TO: Jean Fraser, Planner
FROM: David Senus, P.E. & Ashley Auger, E.I.T.
DATE: December 2, 2013
RE: 118 on Munjoy Hill, Level III Site Plan Review

Woodard & Curran has reviewed the Level III Site Plan Application for the development project located at 118 Congress Street in Portland, Maine. The project will involve the construction of a new four story mixed-use building consisting of residential units and retail space.

6 PAVEMENT CUTTING & MATCHING SECTION  
NOT TO SCALE

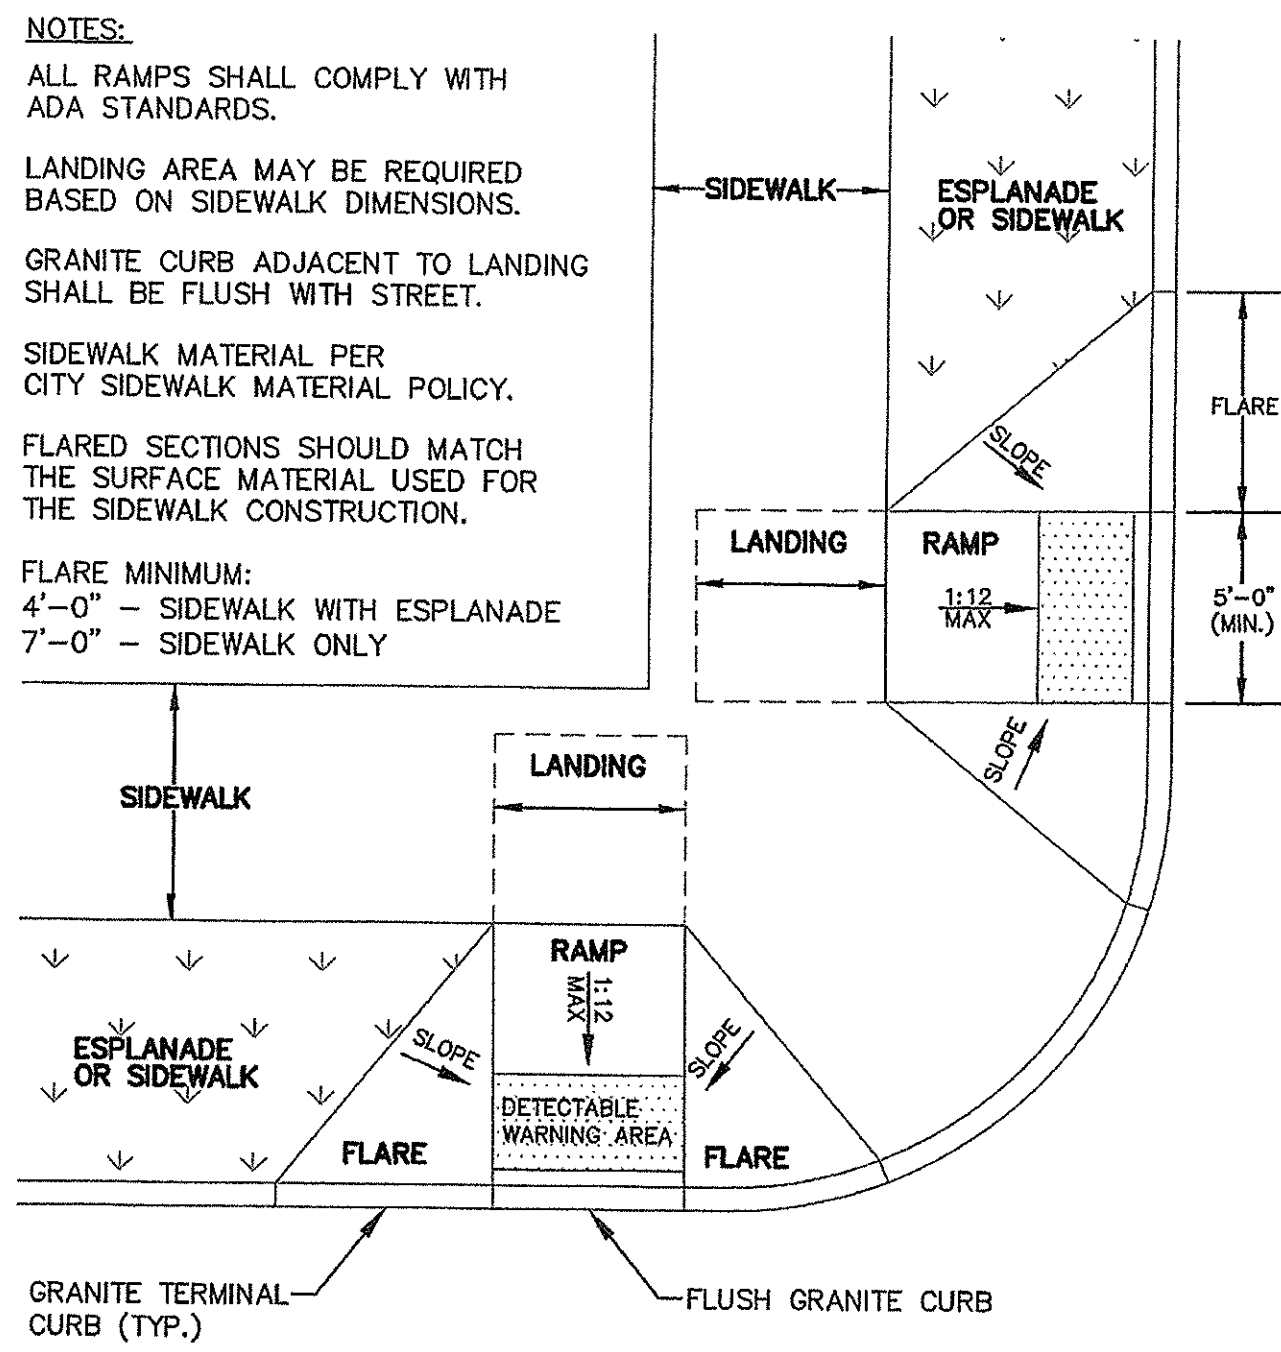
- b) Pavement Repair Cross Section

1 CITY OF PORTLAND BRICK SIDEWALK/CURB DETAIL
L2.0 NOT TO SCALE

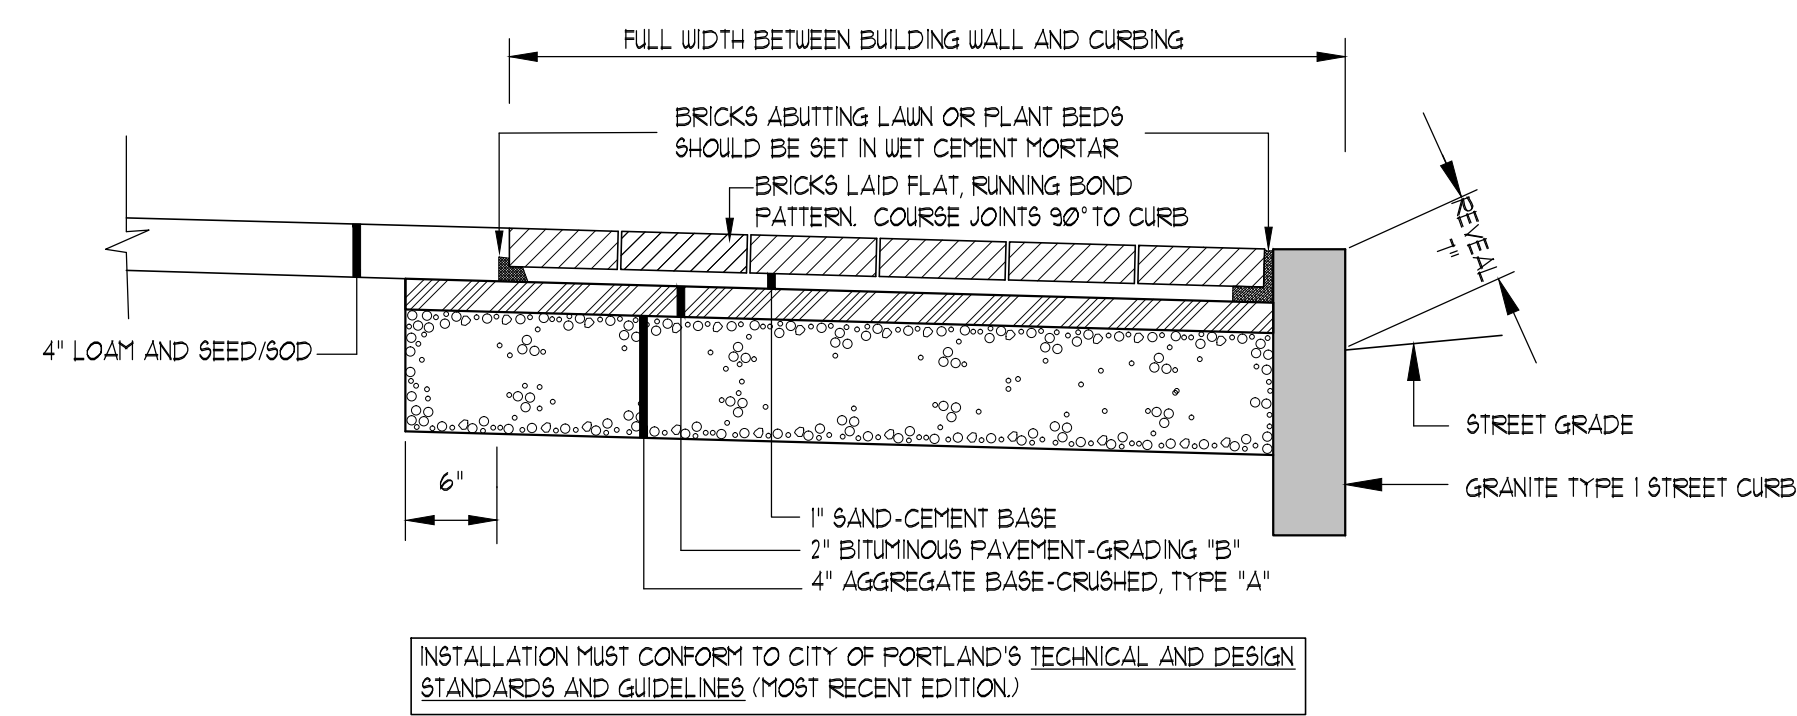
- 3) The following details should be added for work within the City Right-of-Way in accordance with the City of Portland Technical Manual:
 - a) Brick Sidewalk
